Rear of 23 to 43 Moor Lane, Gomersal, Cleckheaton - (KIRK) Discharge of details reserved by conditions 16, 17, 18, 19, 20 (drainage) on previous permission 2023/92079 for outline application for erection of residential development of 10 dwellings, demolition of existing extension at 27 Moor Lane, widening of existing access and realignment of boundary walls

Yorkshire Water object to the discharge of conditions 16, 17, 18, 19 and 20.

The drainage details submitted on drawing PV2511-APP-92-XX-DR-C-2500 (revision P01) dated 26/09/2025 that has been prepared by Align Property Partners require amendments. The following point should be addressed:

Client: PPJ Developments
 Project Name: Land rear of 23-43 Moor Lane, Gomersal, Cleckheaton, BD19 4LF
 Drawing Title: Drainage Plan

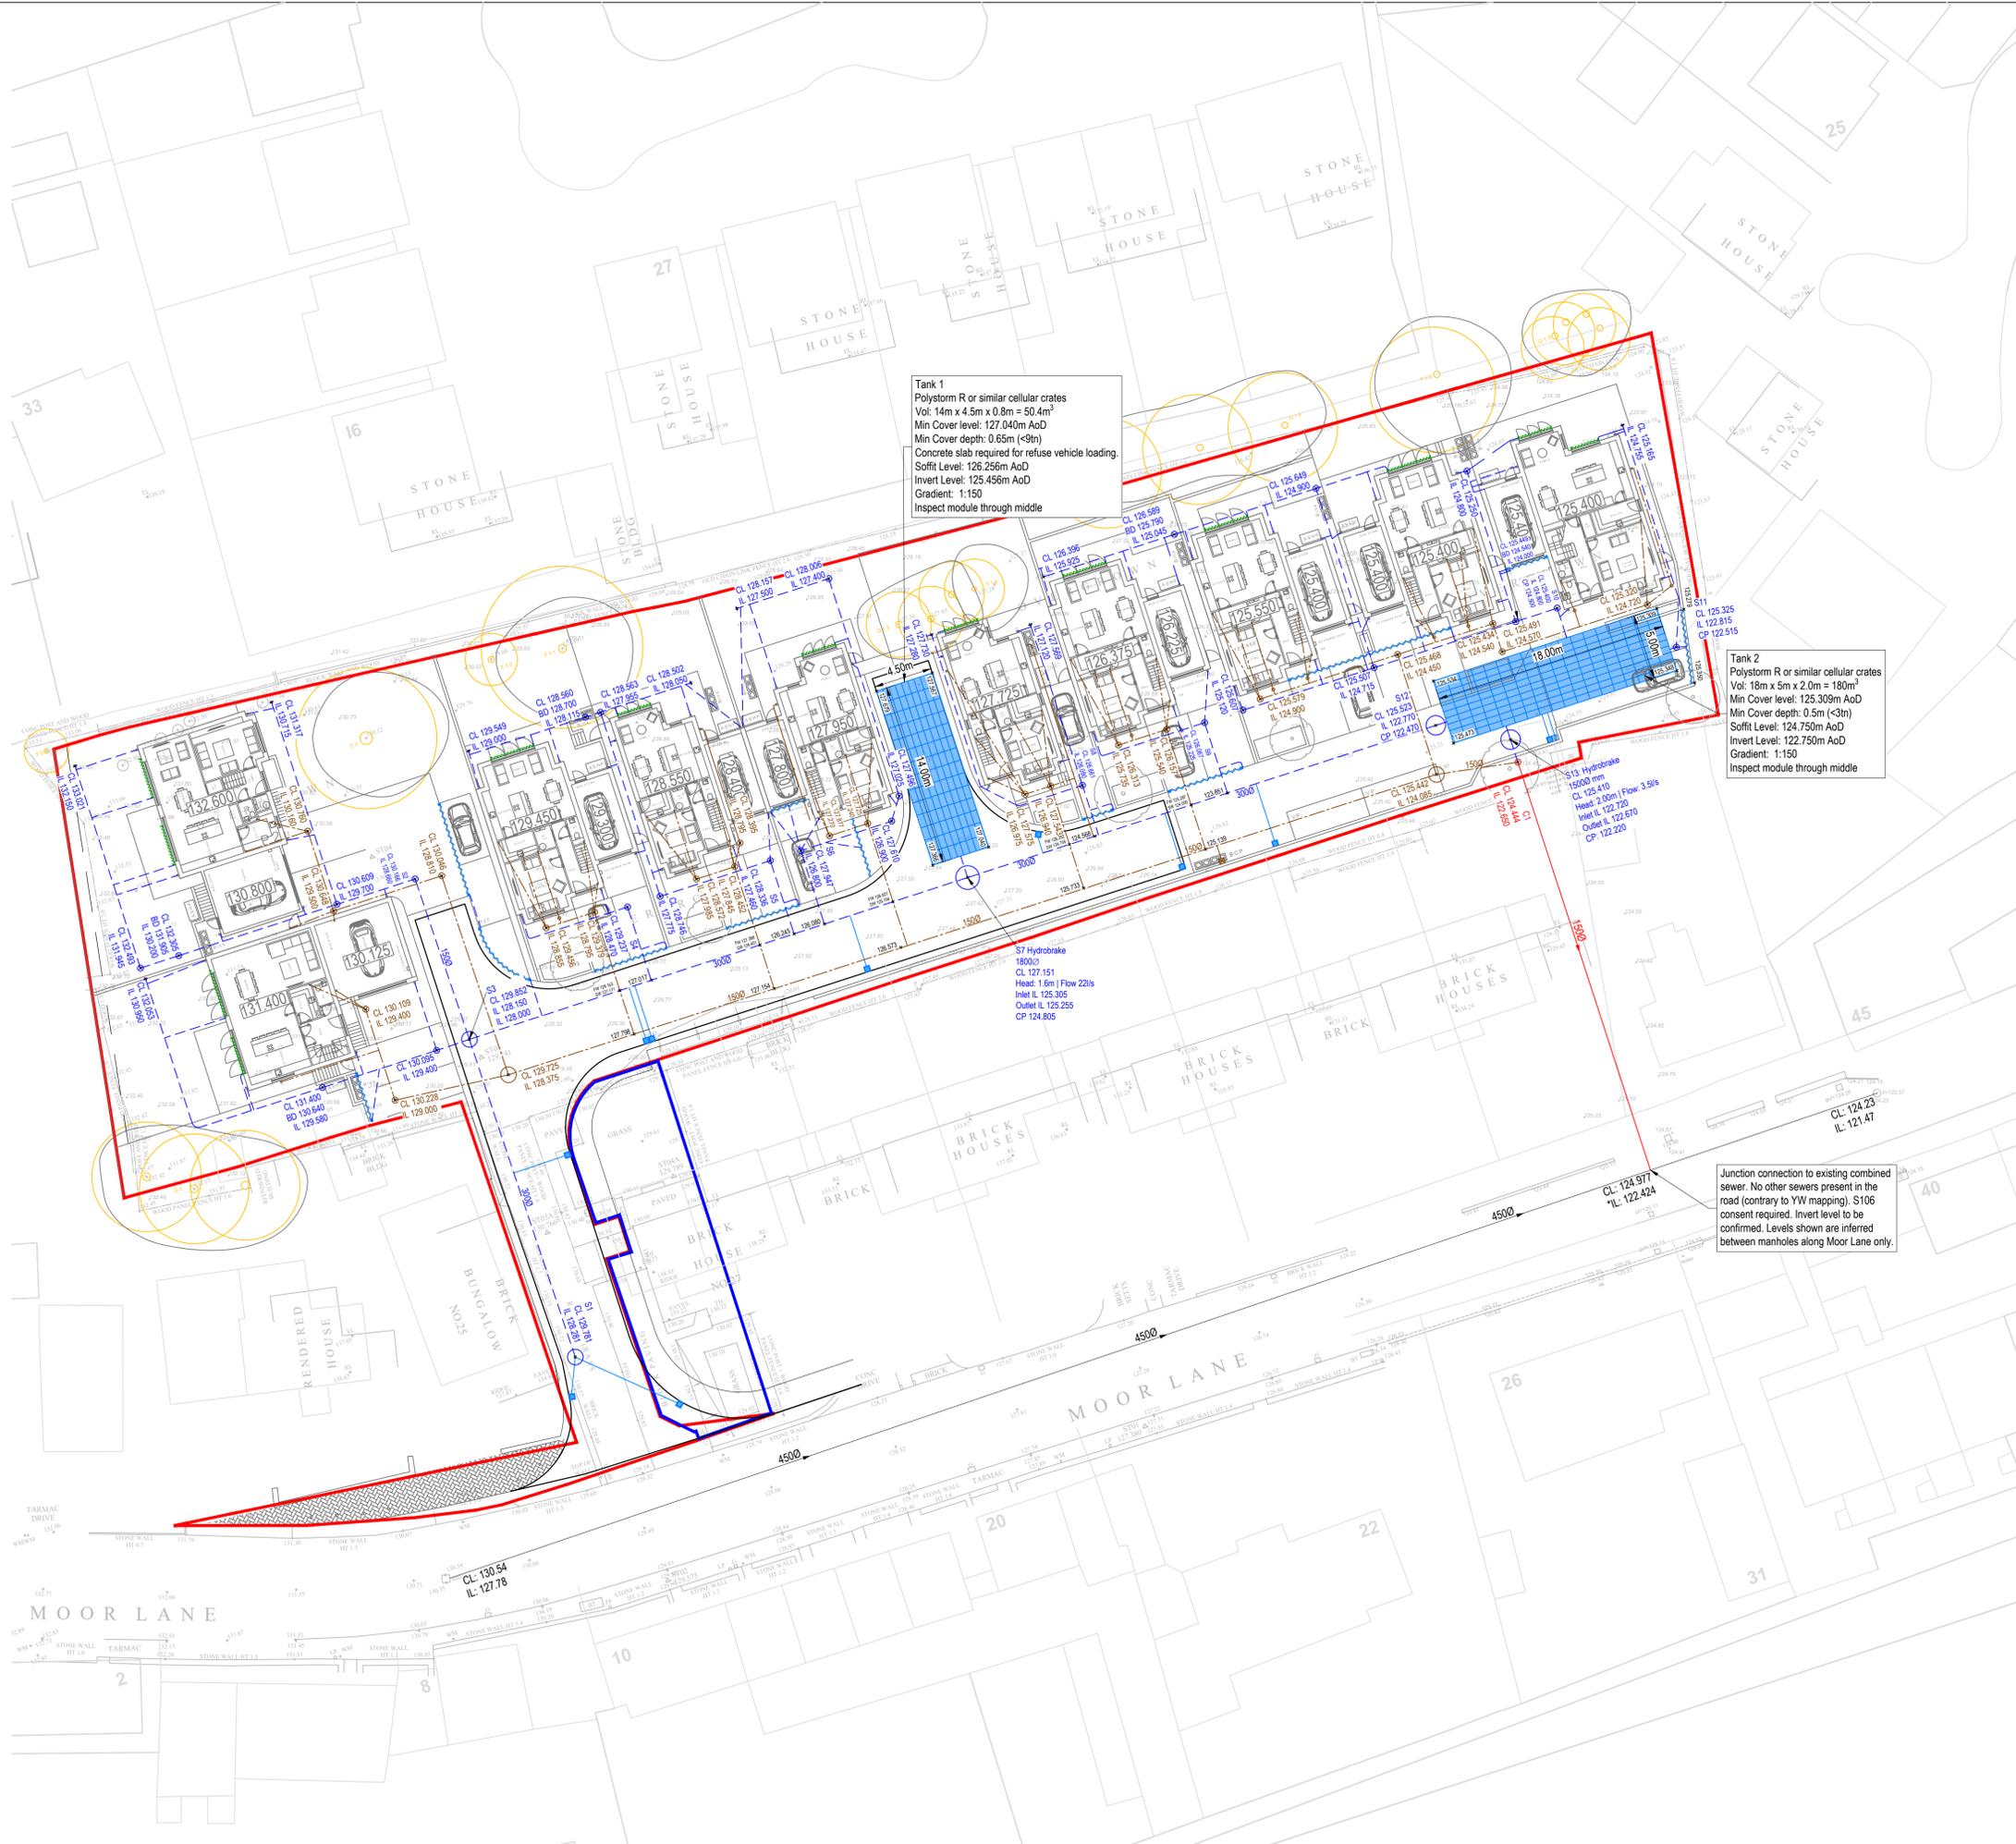
1) the submitted drawing shows a single combined connection discharging to a 450mm diameter combined sewer in Moor Lane, this is not acceptable. Yorkshire Water's records indicate there are two separate public systems in Moor Lane, a 300mm diameter surface water sewer and a 450mm diameter combined sewer. Surface water flow from the development must discharge to the public 300mm diameter surface water sewer in Moor Lane.
